RE: REQUEST FOR ADDITIONAL INFORMATION – SSDA 7388 MOD 8

This submission has been prepared by Ethos Urban on behalf of Grocon (Darling Harbour) Developments (Grocon), in response to the Request for Additional Information (RFI) issued by the Department of Planning and Environment (DPE) on 30 May 2019, relating to SSDA 7388 MOD 8. SSDA 7388 MOD 8 seeks approval for internal changes to the approved IMAX Building as modified. It is noted that the proposed modification will facilitate the future fit-out of the IMAX Theatre as concurrently sought under SSDA 8839.

Podium Level 4

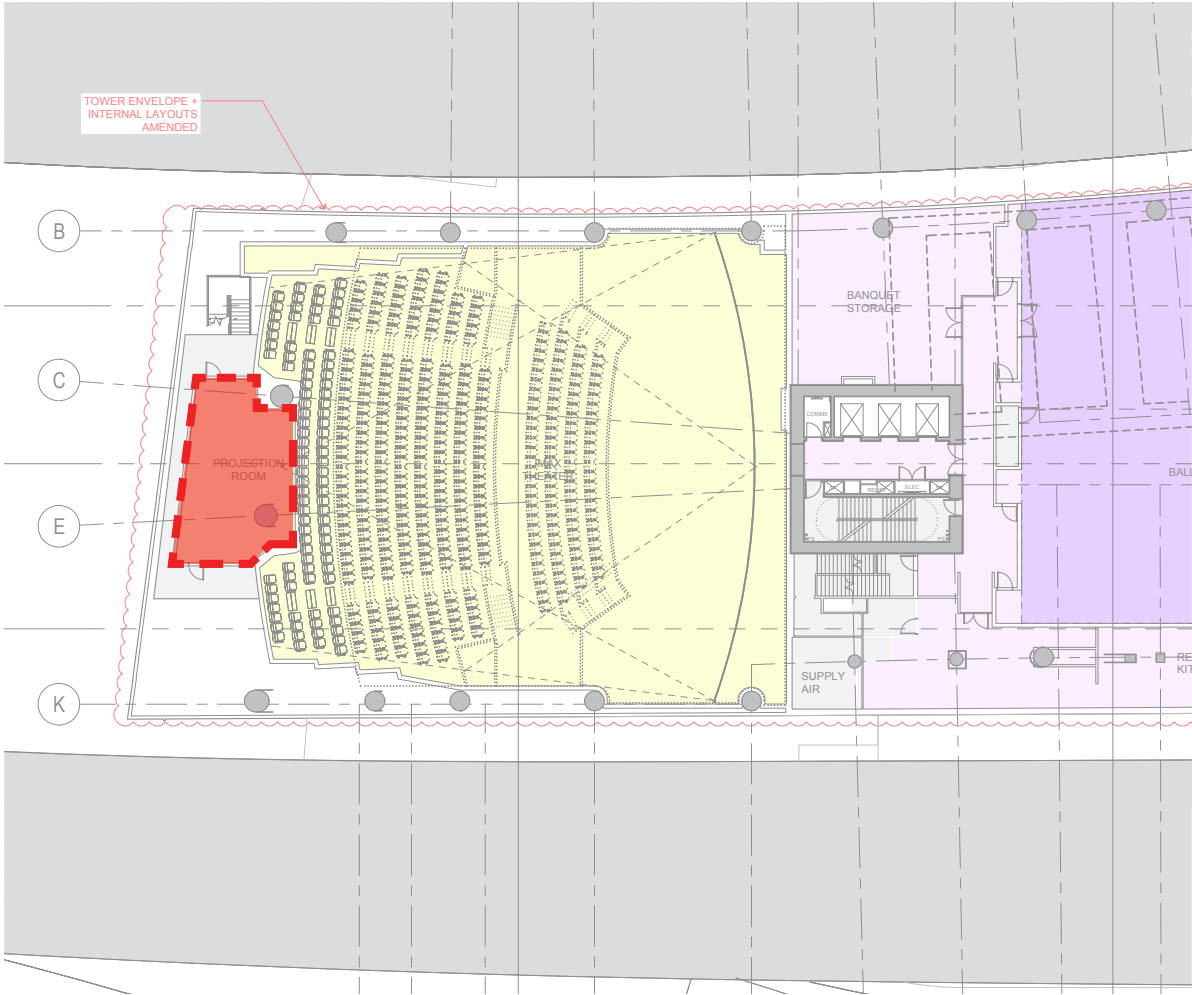
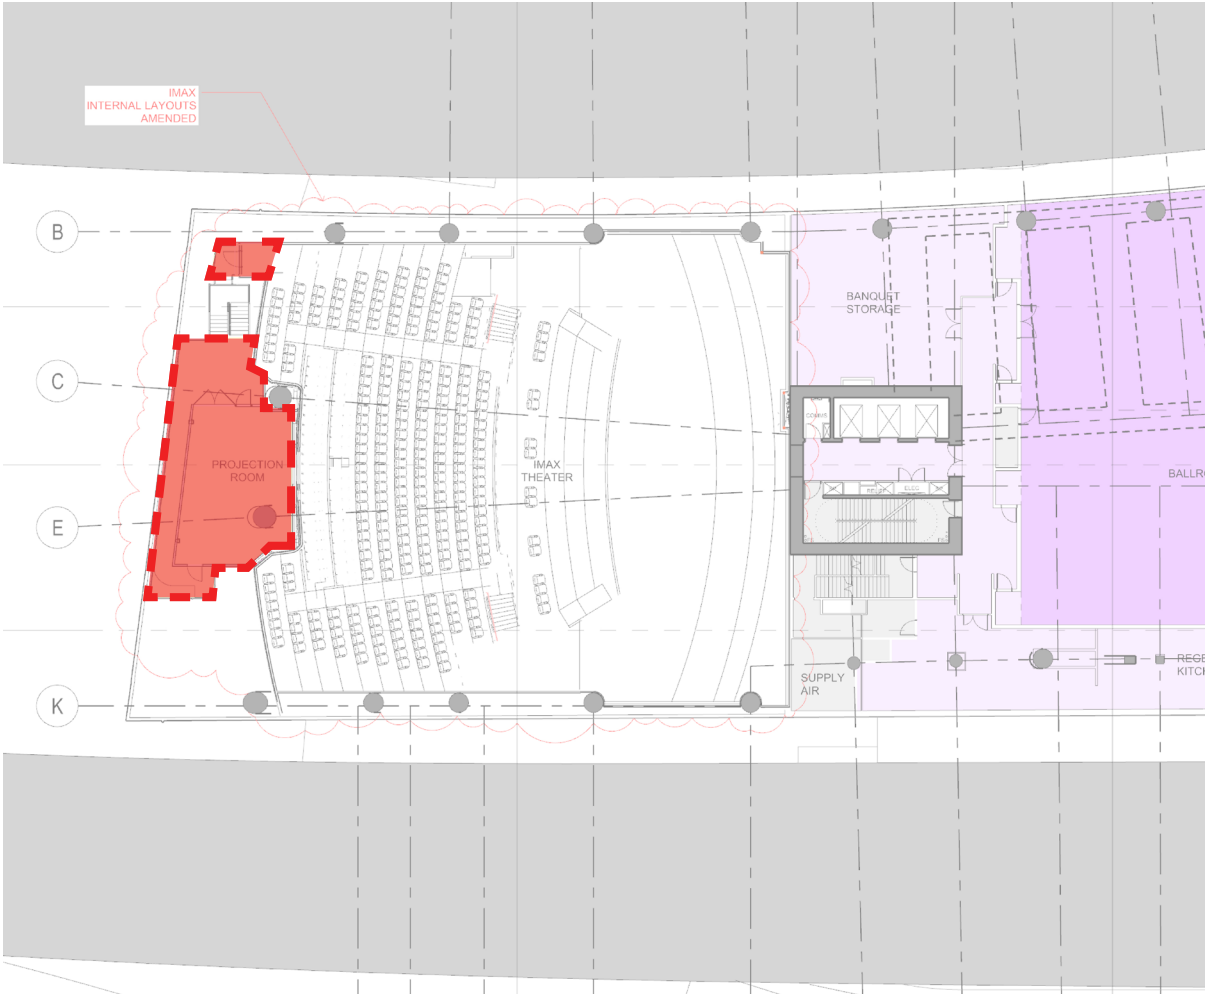
The RFI also identifies an inconsistency of building level identification. This is relevant to the 'moving the projection room from the 4th podium floor (L04) to the 5th podium floor (L05)' as sought under the SSDA 7388 MOD 8 application. This identified change was due to an inconsistency between the level numbering in the IMAX Fit Out Application (SSD 8839) and this modification application (SSD 7388 MOD 8). As such, there is no material movement of the projection room from Level 4 to Level 5, and this modification is no longer sought as a change.
